MORGAN AND MORECAMBE OFFSHORE WIND FARMS: TRANSMISSION ASSETS

Annex 2.2 to Applicants' Response to Deadline 4 submissions from Statutory Consultees and other organisation: Fylde Borough Council (REP4-134)

Deadline: Deadline 5
Application Reference: EN020028

Document Reference: S_D5_2.2

**Figure 1.2: Phase 1 habitat survey coverage**

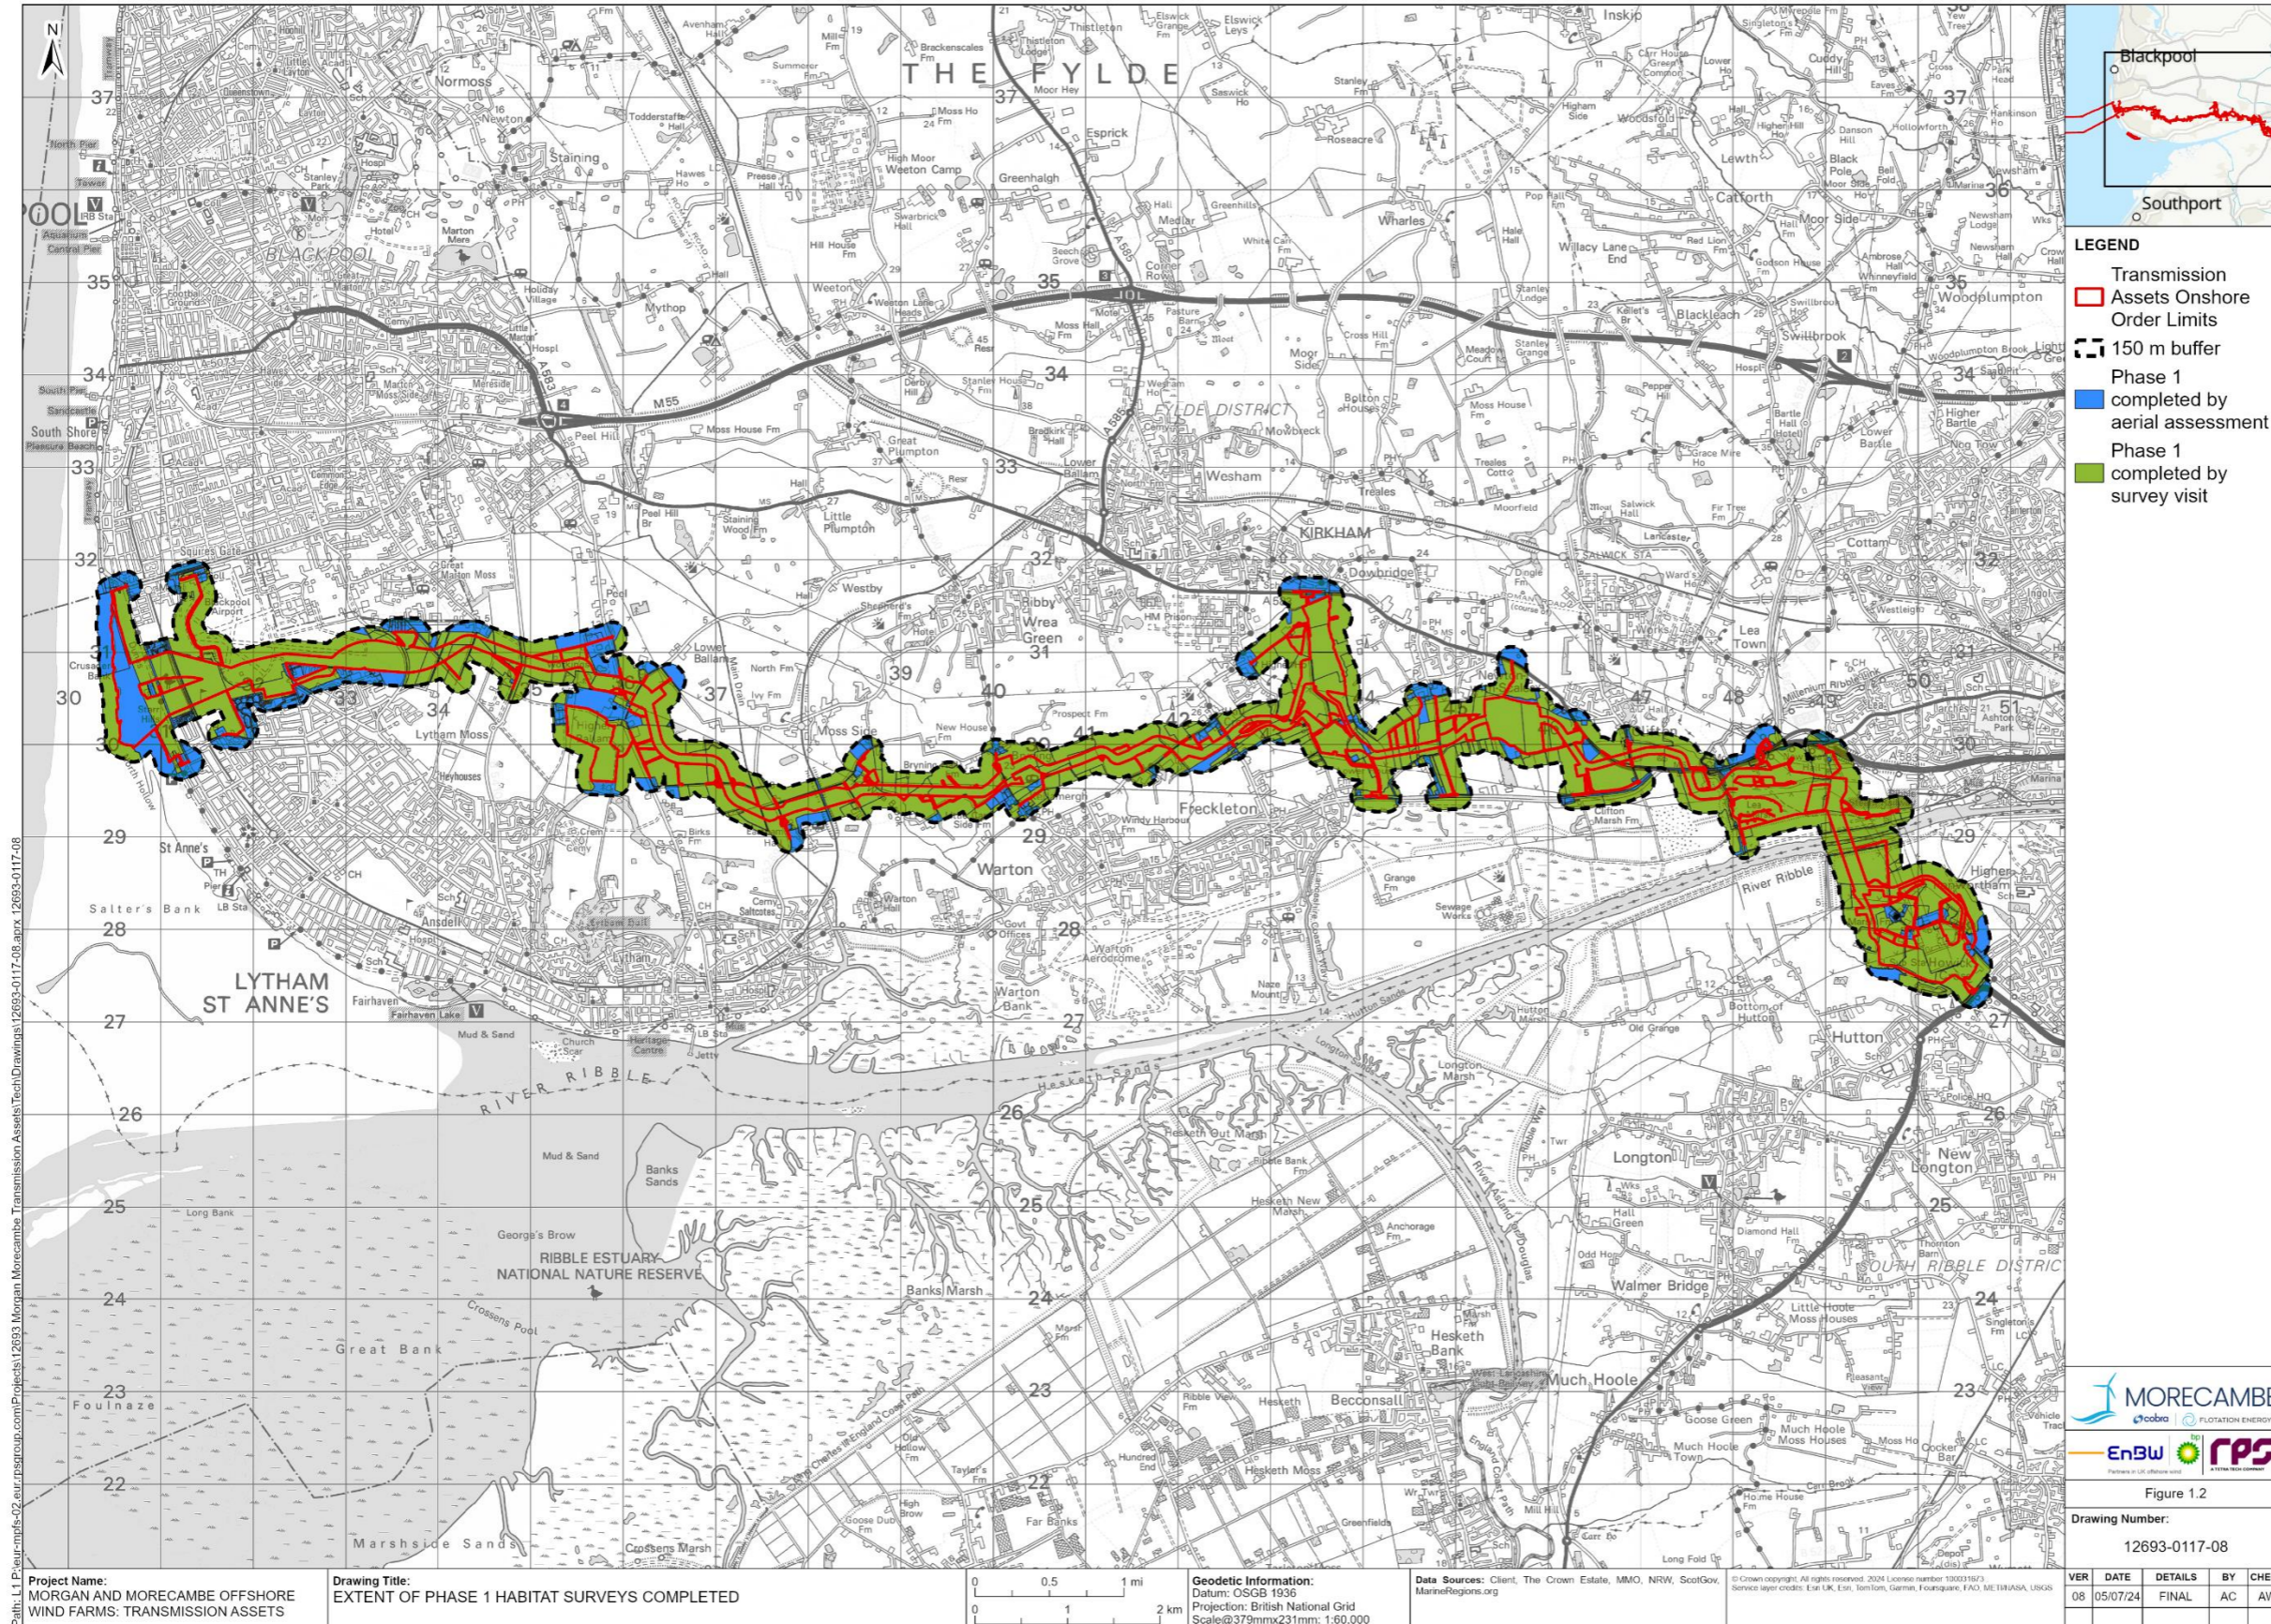
Reference	IP submission	Applicants' response
	<p>6.6.3 FBC raised concerns about the amount of land identified for these purposes which has not been surveyed. FBC considers that it is not possible to understand the carrying capacity and overall suitability of land, without carrying out an appropriate level of surveys. At present, the high level of uncertainty increases risk, giving rise to an increase in likely harm.</p>	<p>Rev 01 (REP4-116)). There are various proposals for biodiversity enhancements for terrestrial ecology including the creation of new ponds, hedgerows, scrub, woodland and species-rich grassland – these measures are commonly delivered for development projects, and the land proposed is considered suitable for the successful delivery of such habitats.</p> <p>Responses related to bird mitigation and carrying capacity are provided in REP4-134.9 above.</p>
REP4-134 134.22	<p>7 Dunes</p> <p>7.1 Sand Dunes – Various matters</p> <p>7.1.2 FBC notes that ExA Questions Q8.1.1-Q8.1.6 relate to geology, hydrology and ground conditions at, where these questions relate to the dunes area.</p> <p>7.1.3 These questions were directed towards Natural England, the Environment Agency, Lancashire County Council and the Marine Management Organisation, and that each of these organisations have provided written responses to these questions.</p> <p>7.1.4 FBC provides comments here which it considers align with submissions already made by these other key parties.</p>	<p>The Applicants note FBC's response.</p>

REP4-134 134.21	<p>6.6 Biodiversity Net Gain / Benefit / Mitigation areas</p> <p>6.6.2 FBC notes the extended discussions around the proposed BNG, biodiversity benefit and mitigation areas.</p>	<p>With regard to the requirements for terrestrial ecological mitigation and biodiversity benefit, all of the land within the areas proposed to be used for these purposes has been surveyed (see S_D4_12 Annex 3.3: Applicants' response to ExQ1 6.1.1: Phase 1 Habitat Survey Coverage -</p>
